**Consultation Response from KC,
Highways Development Management**

**2025/93546 Land adj Healey Junior Infants and Nursery School, Healey lane, Healey, Batley,
WF17 8BN**

Variation conditions 2 (plans), 10 (temporary drainage), 13 (highway structures), 12 (road safety), 17 (landscape), 26 (levels) on previous permission 2024/91760 for erection of 19 dwelling houses with associated car parking, landscaping and boundary treatment and other associated works

Date Responded: 30/03/2026

TITLE
**HIGHWAY LONGITUDINAL
SECTIONS**

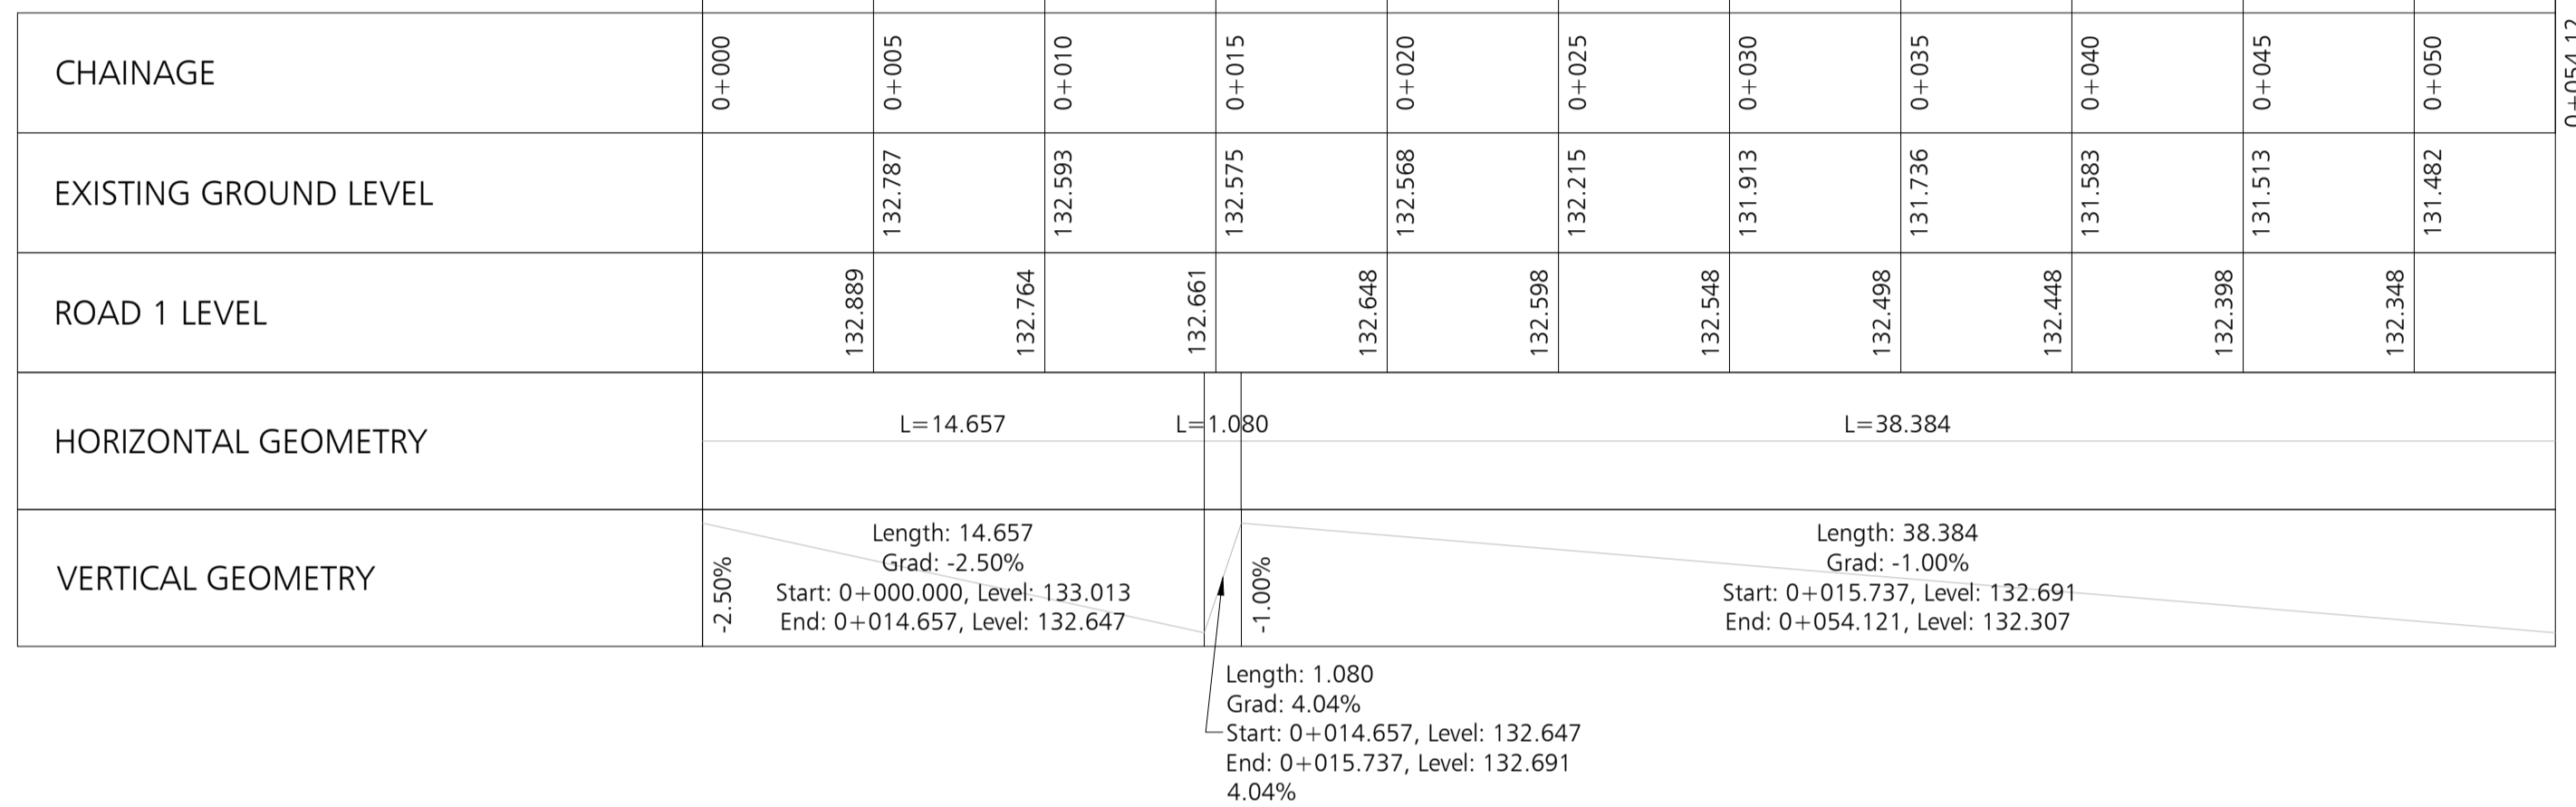
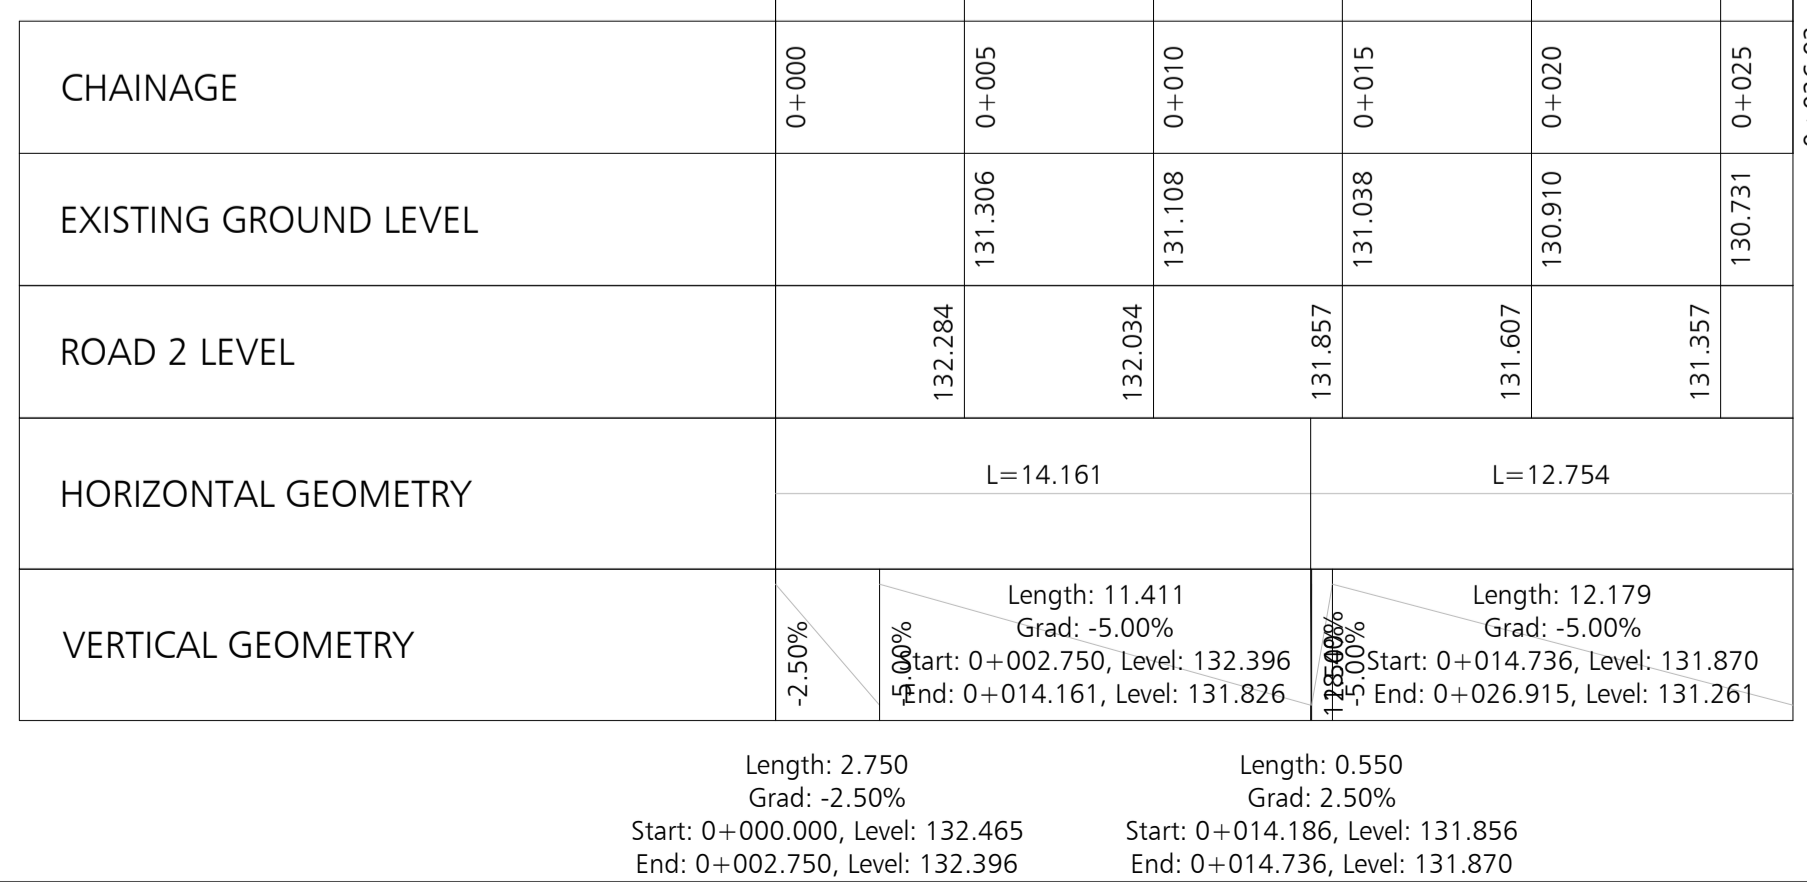
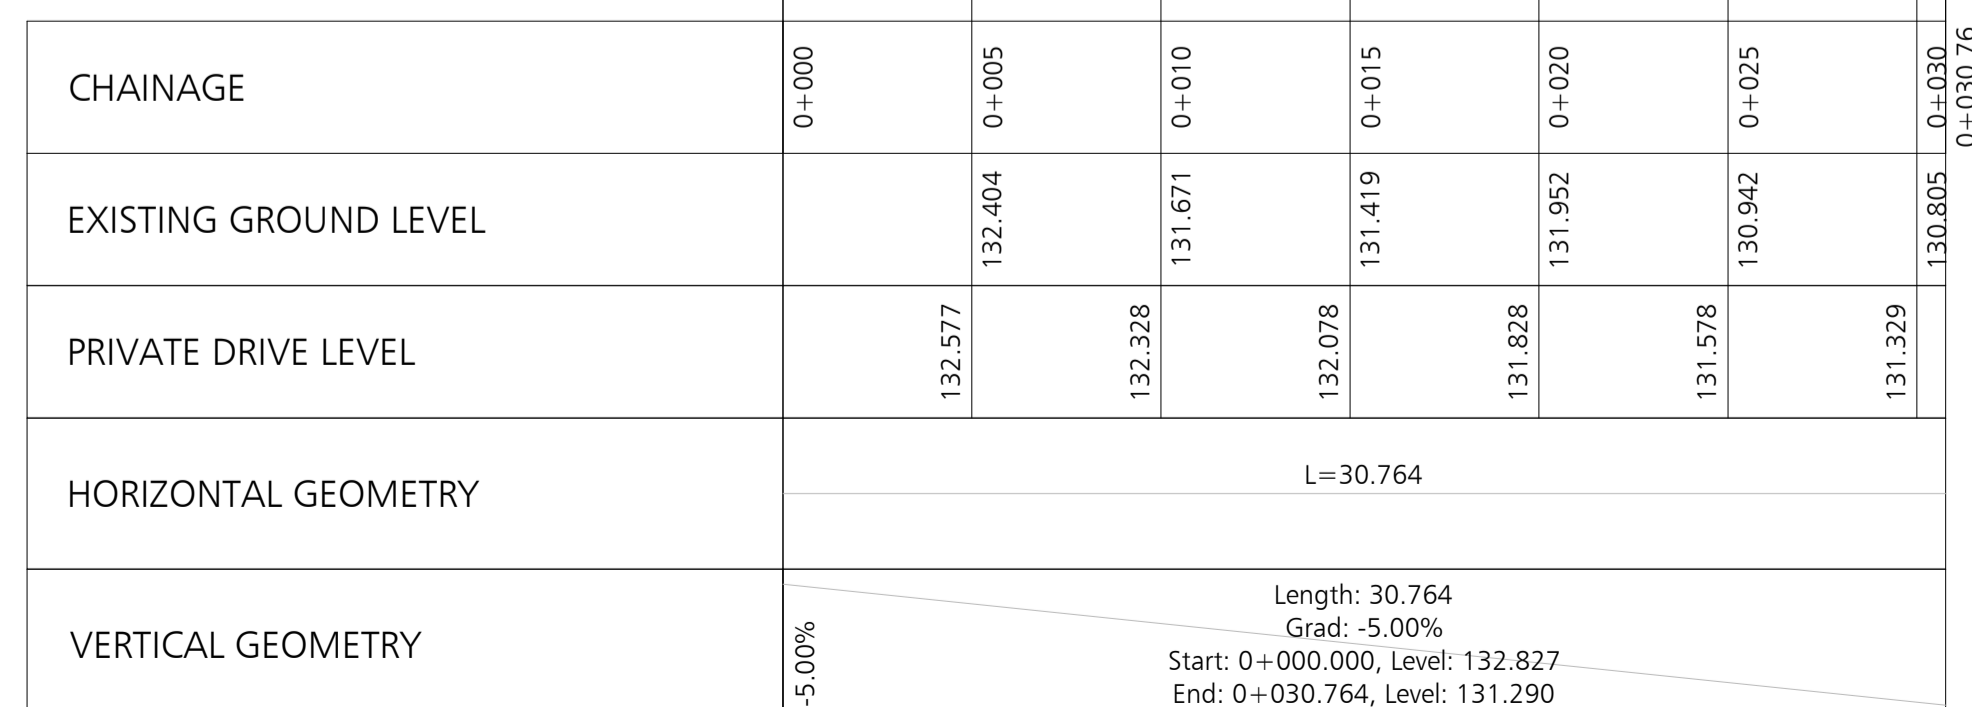
Kirklees s38 team have confirmed that they have received long sections and they are acceptable for adoption under a s38 agreement and so part a. of condition 12 can now be discharged. The stage 1 Road Safety Audit was signed off by the Overseeing Organisation on 18/03/25 and so part b. of condition 12 can be discharged if this has not already been authorised.
